Application by Norfolk Boreas Limited for the Norfolk Boreas Offshore Windfarm
The Examining Authority's fifth round of written questions and requests for information (ExQ5)
Issued on 11 August 2020

Responses are due by Deadline 14: 25 August 2020

Norfolk Boreas Offshore Wind Farm Plan showing the 12m planting gap

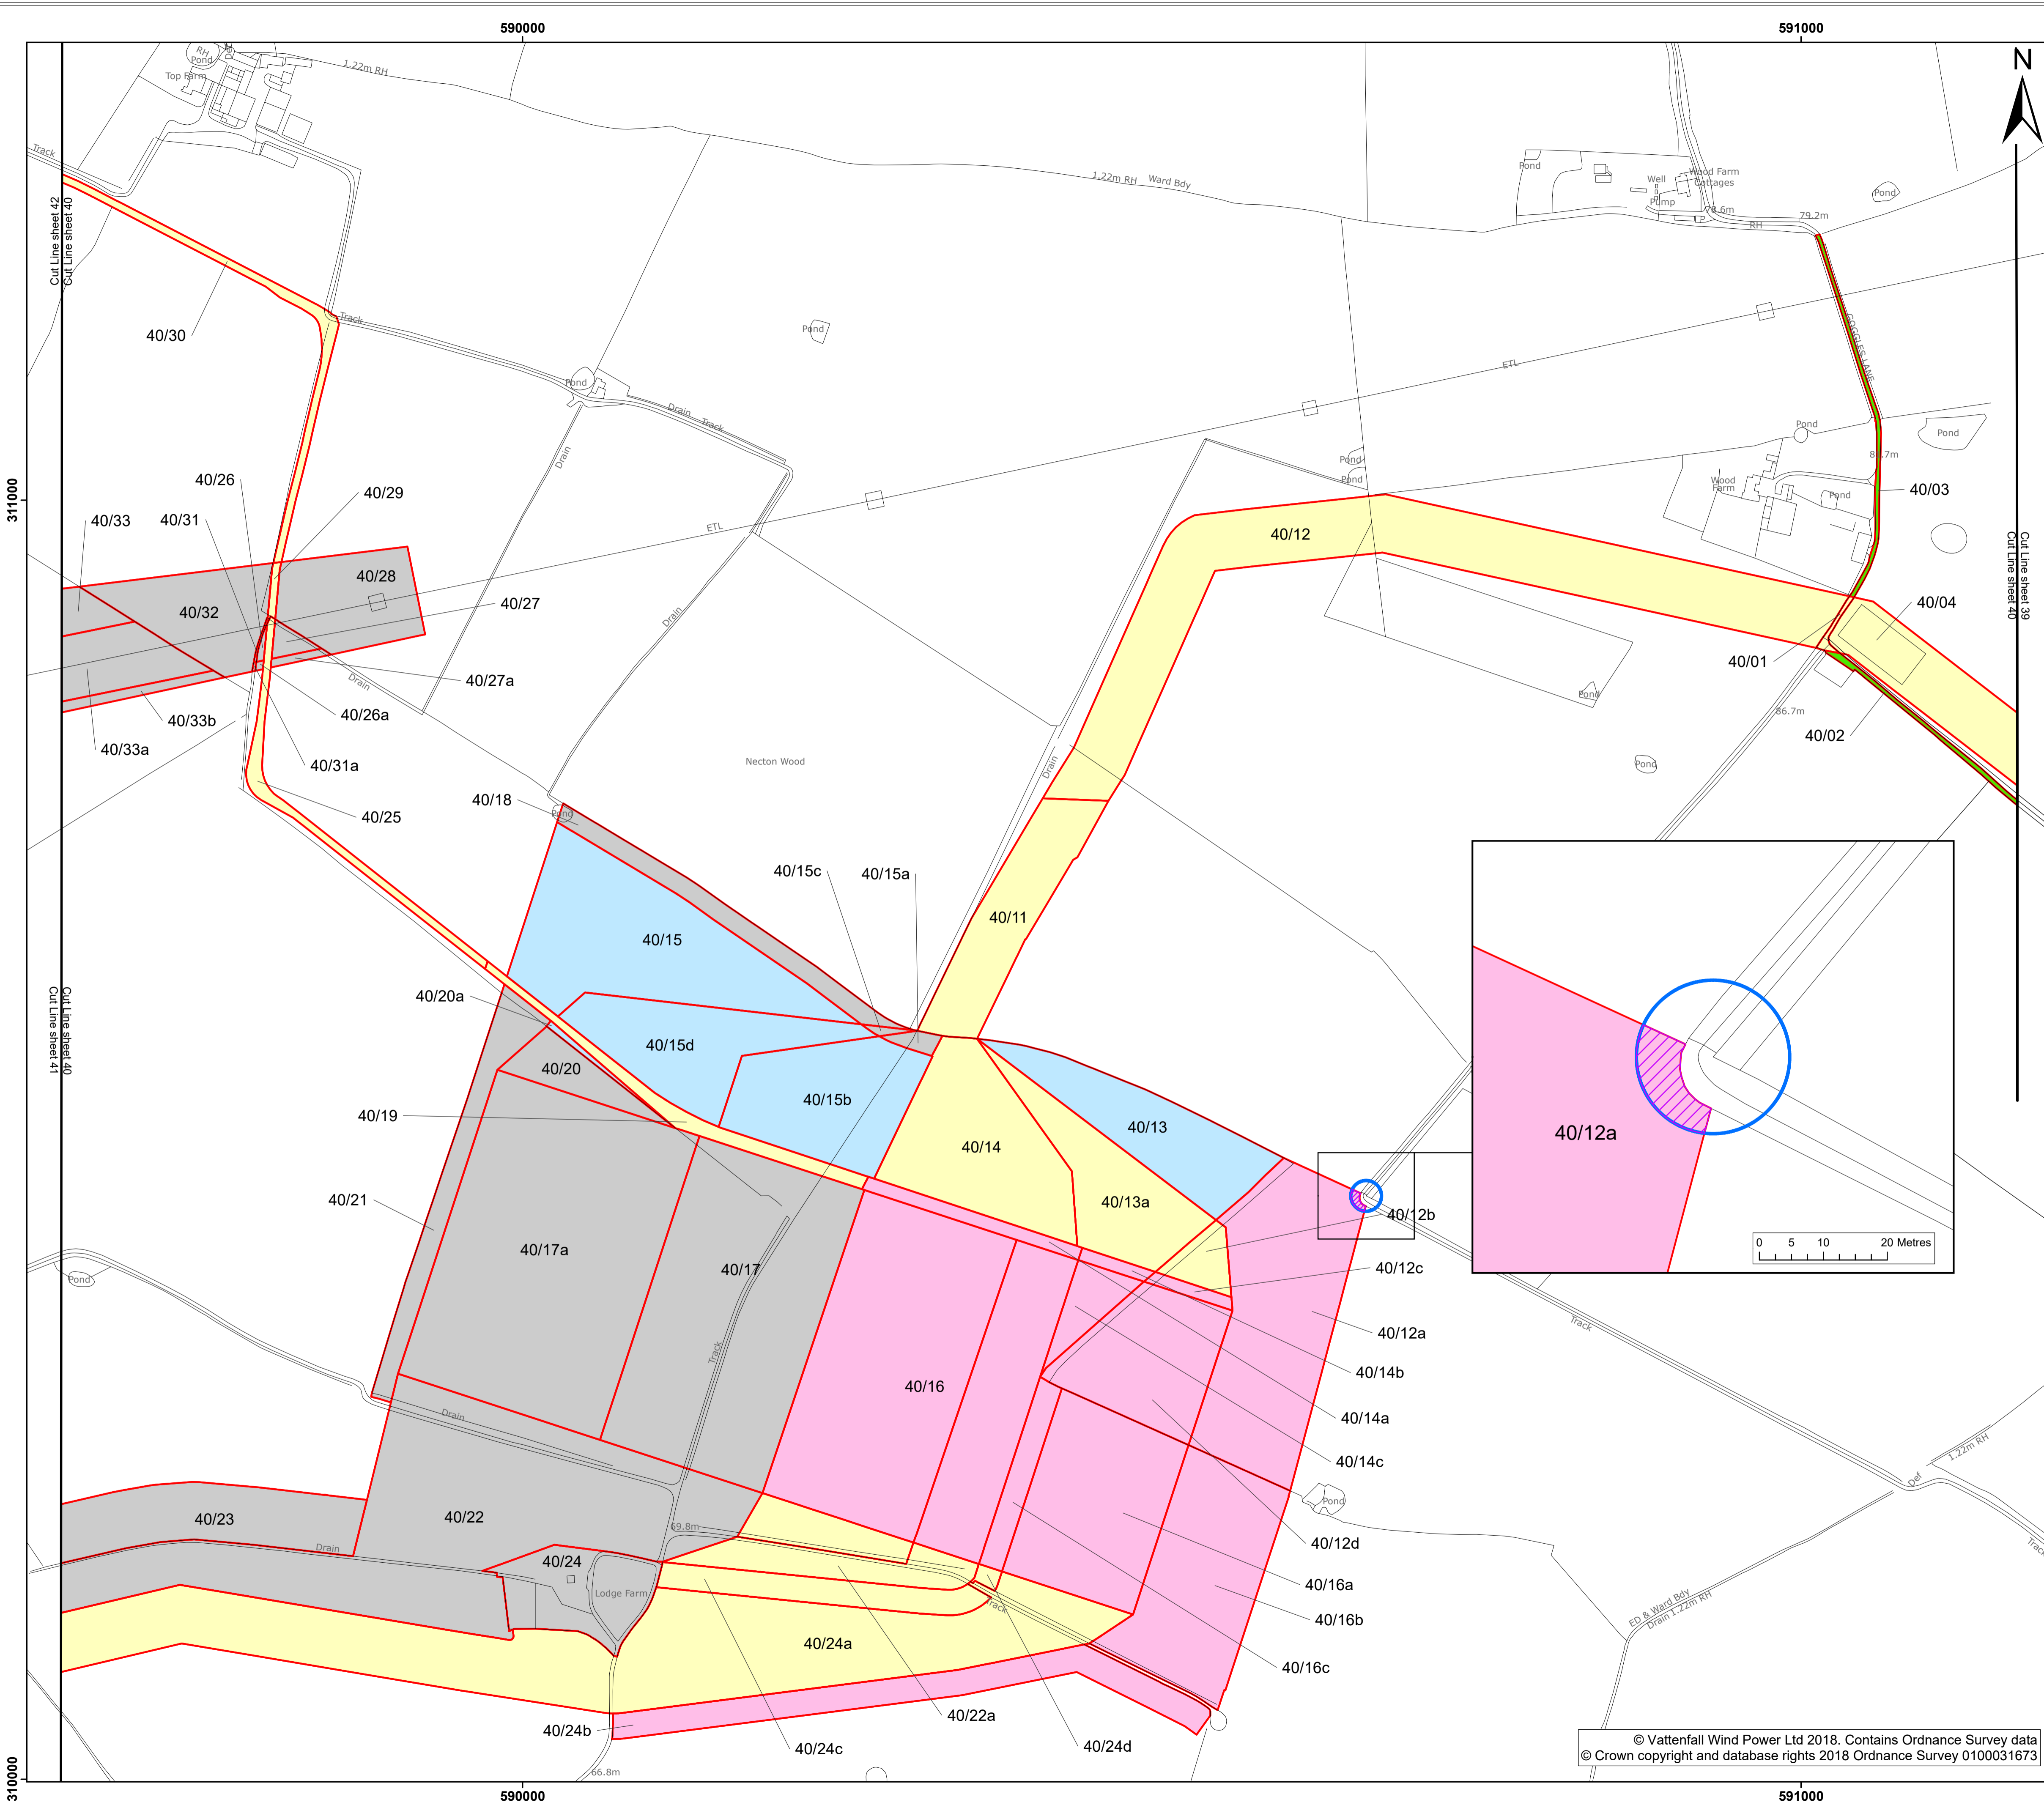
9.3	Landscape effects	
	No questions	
9.4	Visual effects	
	No questions	
9.5	Outline Landscape and Ecological Management Strategy (OLEMS) and Design and Access Statement	
Q5.9.5.1	The Applicant	<p>Onshore project substation 12m access strip for large machinery</p> <p>Further to the Land Plan showing the "area to be cleared of landscaping obstruction" [REP13-020], include a cut-out plan in the DAS which illustrates the adjustments to the mitigation planting in the north east corner of the Order Limits for the onshore project substation from that currently shown on the Scenario 1 Mitigation Planting Plan [REP7-010, sheet 3 of 8].</p>
Q5.9.5.2	The Applicant; National Grid	<p>Finishes for National Grid substation extension</p> <p>a) Further to requests and comments at OFH3, can the electrical equipment required for the National Grid substation extension be coated or manufactured with a matt finish?</p>
